Subject: Shoreline Exemption Permit, Pump Station 21 – 8000 Avalon Drive.

This is a written response to the review comments provided by the Community Planning and Development Department regarding the application for the Shoreline Exemption Permit, SHL23-008, for Pump Station 21 located at 8000 Avalon Drive.

PUMP STATION 21 - 8000 AVALON DRIVE

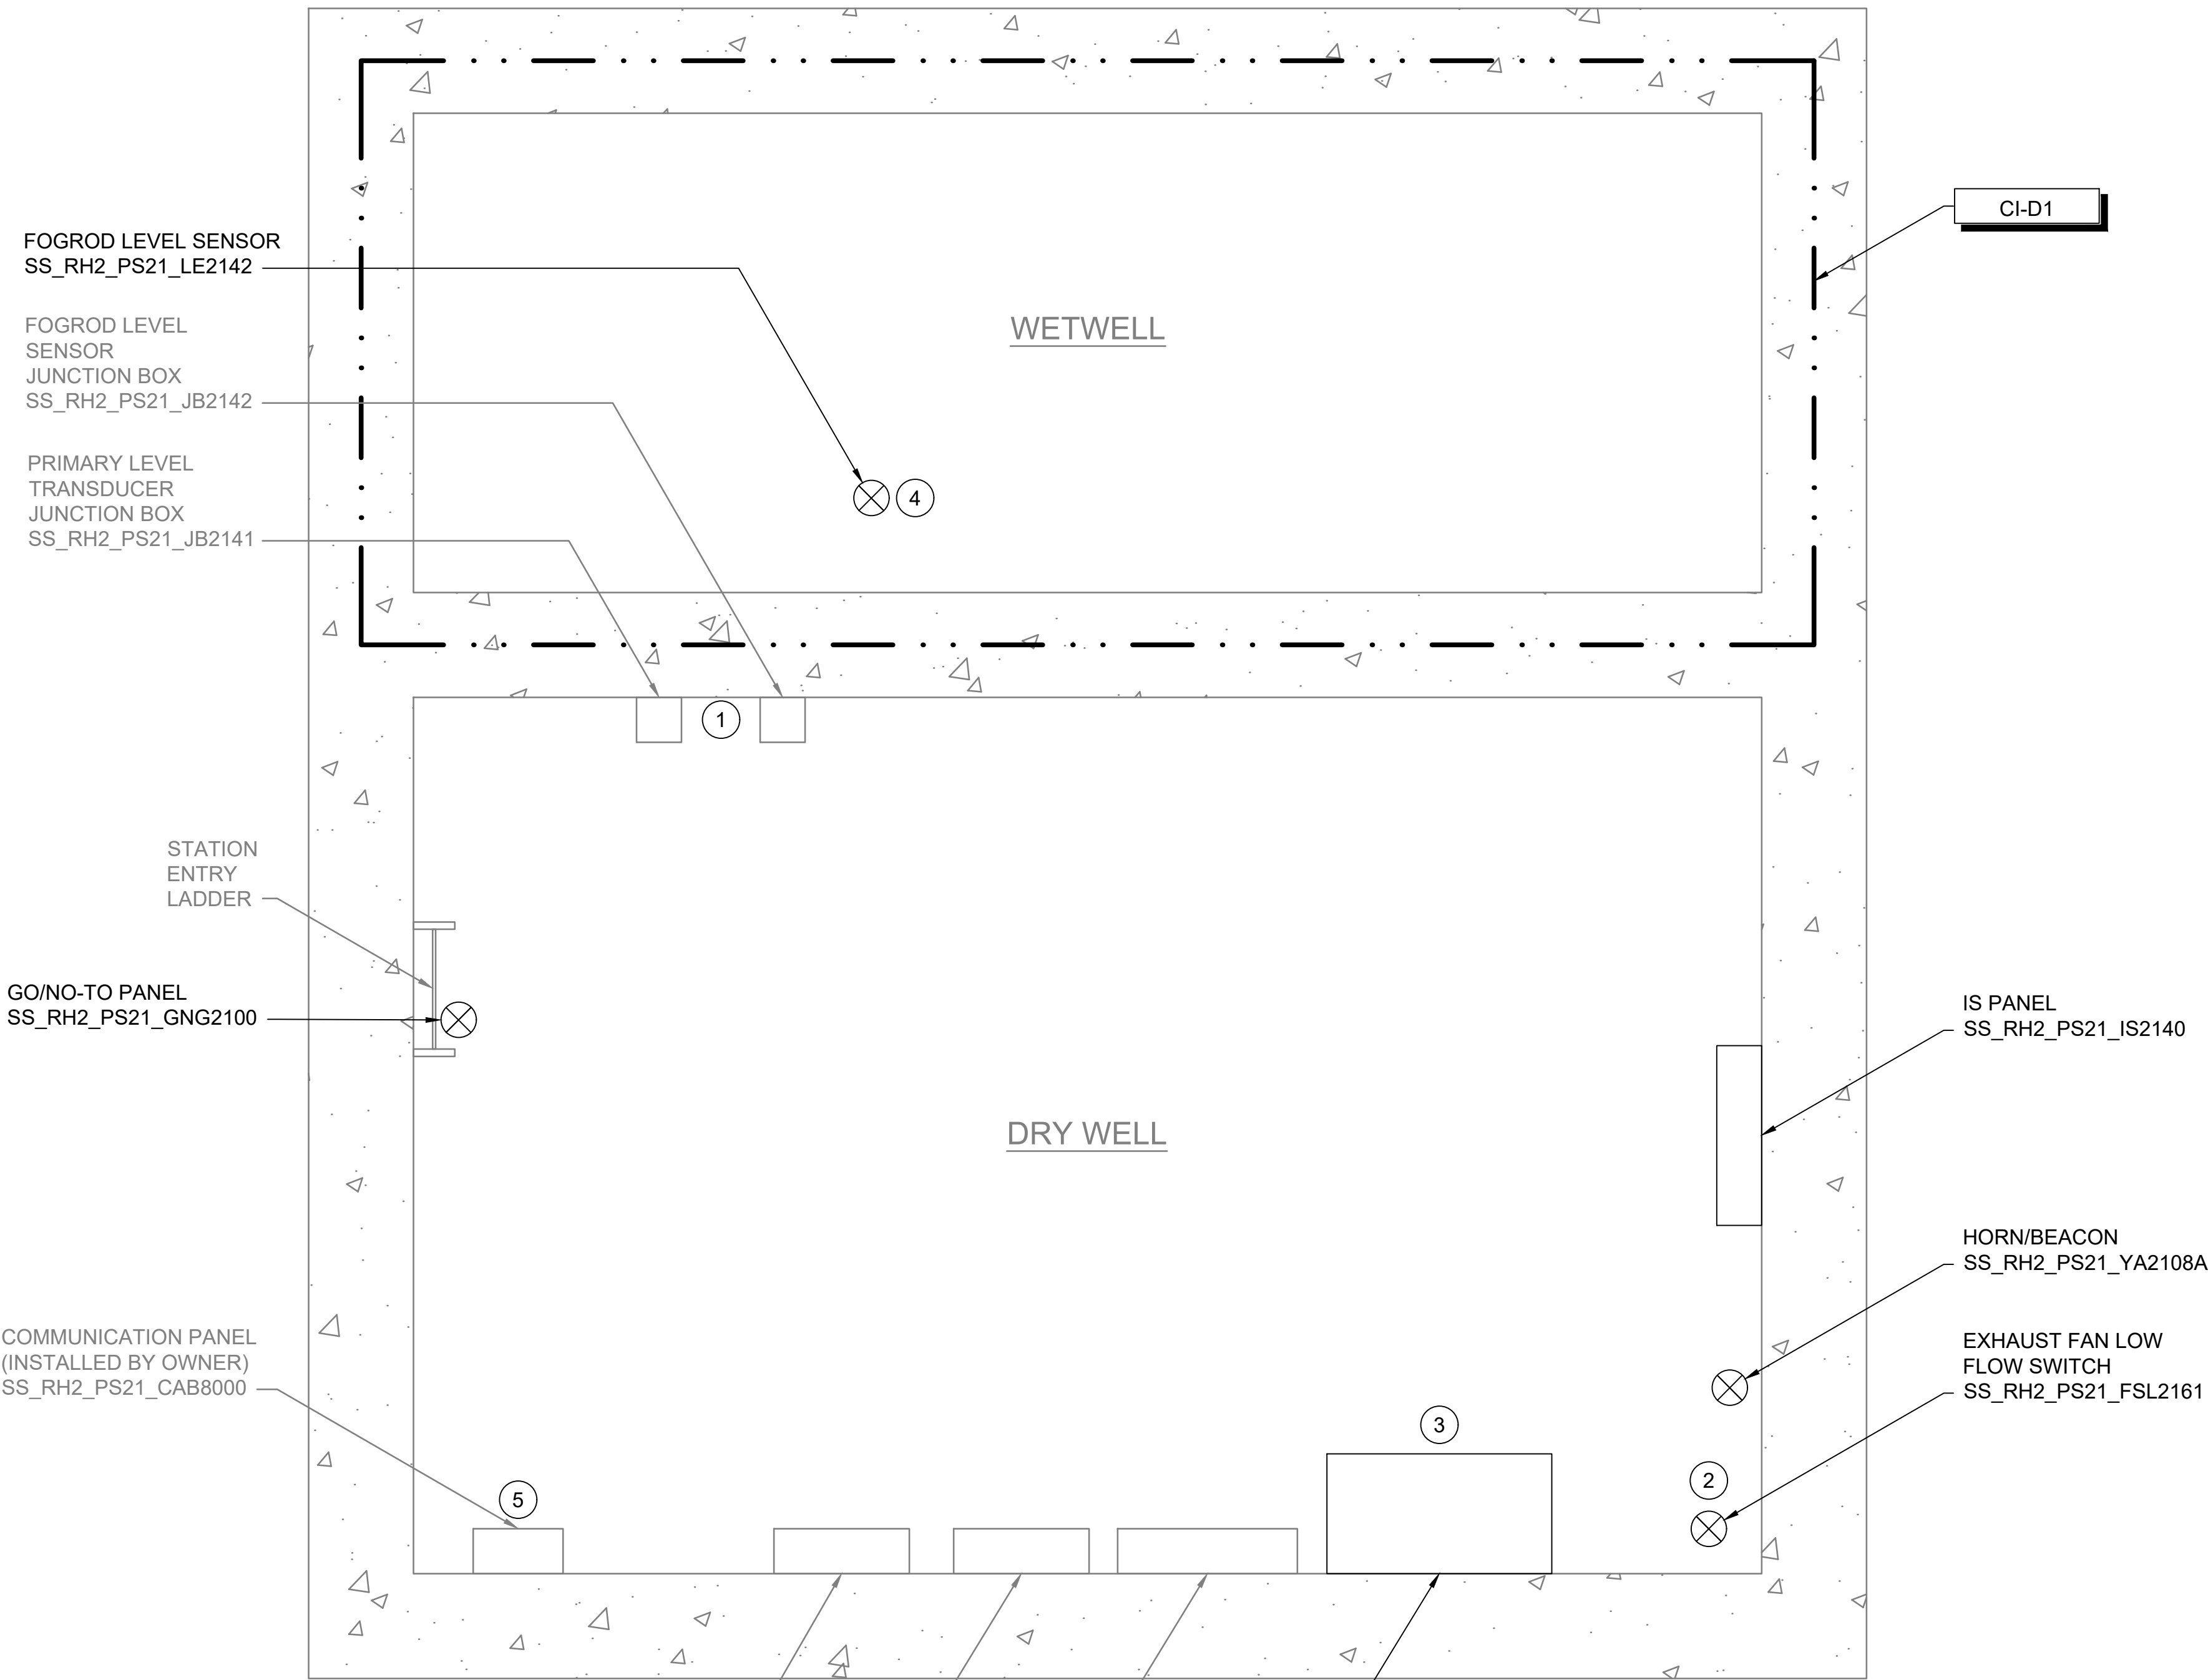
- a. Provide address of all pump stations on plans

**Response:** *The address for the pump station has been added to Development Plan, Instrumentation Drawing page 1. The address was also included in the aerial photo of the pump station.*
